DECISION DELEGATED TO HEAD OF PLANNING

Application No: H03-0797-24 **Applicant:** Mrs J Wenman
Proposal: Garage extension to form annexe
Location: 1 Herdsmans Close Deeping St Nicholas Spalding
Terminal Date: 14th November 2024

DRAWING NUMBER	REV
RJW-2609-24-01

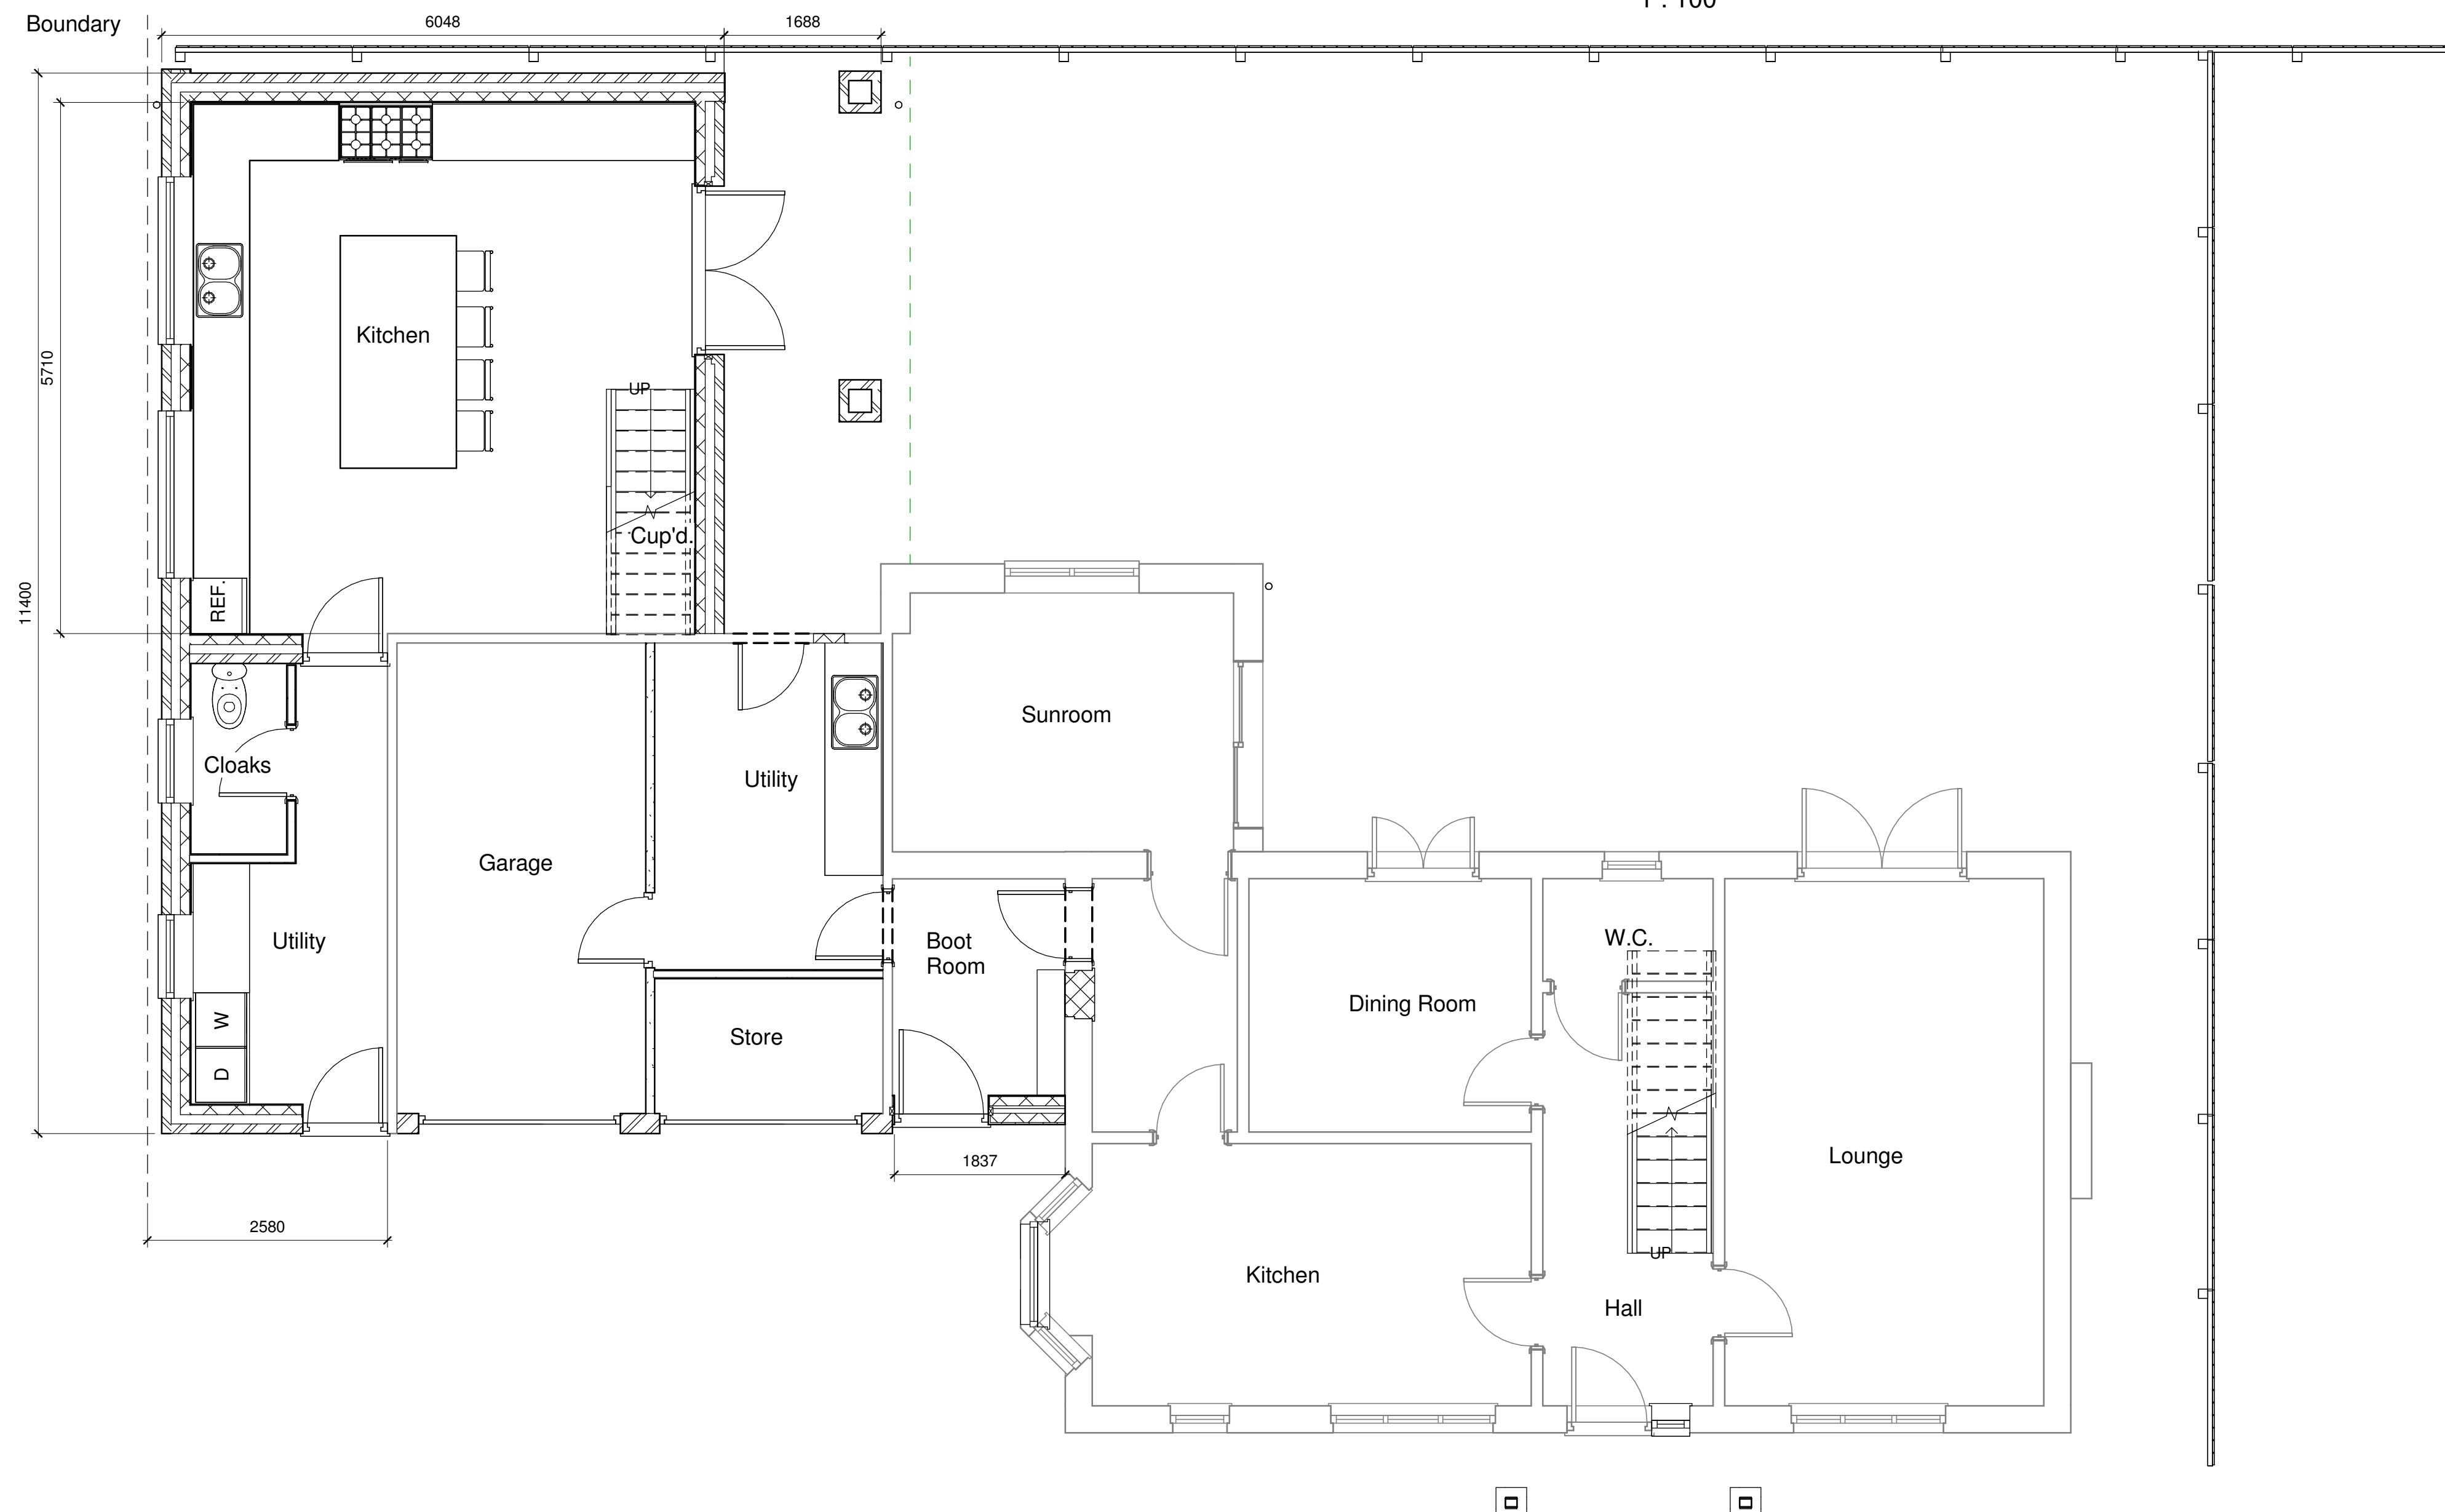
provide a 'boot room'. The garage currently features a gable end roof form and the proposed extension would also feature a gable end roof form, however, the ridgeline would be taller. The ridgeline of the existing garage measures 4m from the ground level, whereas the proposed extension would measure 6.5m. The proposed ridgeline would therefore nearly be as tall as the ridgeline of the main dwelling.

The existing garage measures 5.4m by 5.5m. The proposed development seeks to extend the garage by approximately 6m, meaning that the annexe would measure 11.4m in length. The extension would measure approximately 6m in width towards the rear of the site, and 7.7m in width towards the front. This is because the roof of the proposed extension covers the proposed link area between the annexe and the main house at the front. Part of the annexe roof therefore would overhang the garden.

As set out above, the proposed extension would be nearly as tall as the main dwelling. Furthermore, the current built volume of the garage is approximately 94 cubic metres, whereas the volume of the proposed extension is approximately 350 cubic metres. This represents a 272% volume increase. Extensions should not dominate the original building in terms of their scale or siting. The proposed extension would be of an excessive scale compared to the main dwelling. The scale of the proposed extension is therefore considered to be unsuitable as it would represent a disproportionate addition to the main dwelling.

The proposed extension would result in the built form moving much closer to the road frontage than the existing garage. Whilst there is no strict uniformity in terms of surrounding plot layouts, most of the nearest dwellings are set back from the road frontage. One of the closest dwellings to the site is 4 Herdsman Close, which is located to the south-west of the site. This dwelling is set back at a similar distance from the road frontage as the existing garage building within the site. The proposed siting of the extension would therefore be unsuitable in this case by introducing a disproportionate addition that would be inappropriately close to the site frontage.

The existing dwelling features four bedrooms, whereas the proposed extension would result in the provision of five bedrooms. The parking requirement would therefore remain three spaces for the dwelling and annexe. Lincolnshire County Council's highways team have queried whether there would be enough space for parking within the site as the proposed development would remove half of the integrated garage, thereby resulting in the loss of one parking space. There would however still be enough room for three parking spaces within the site.
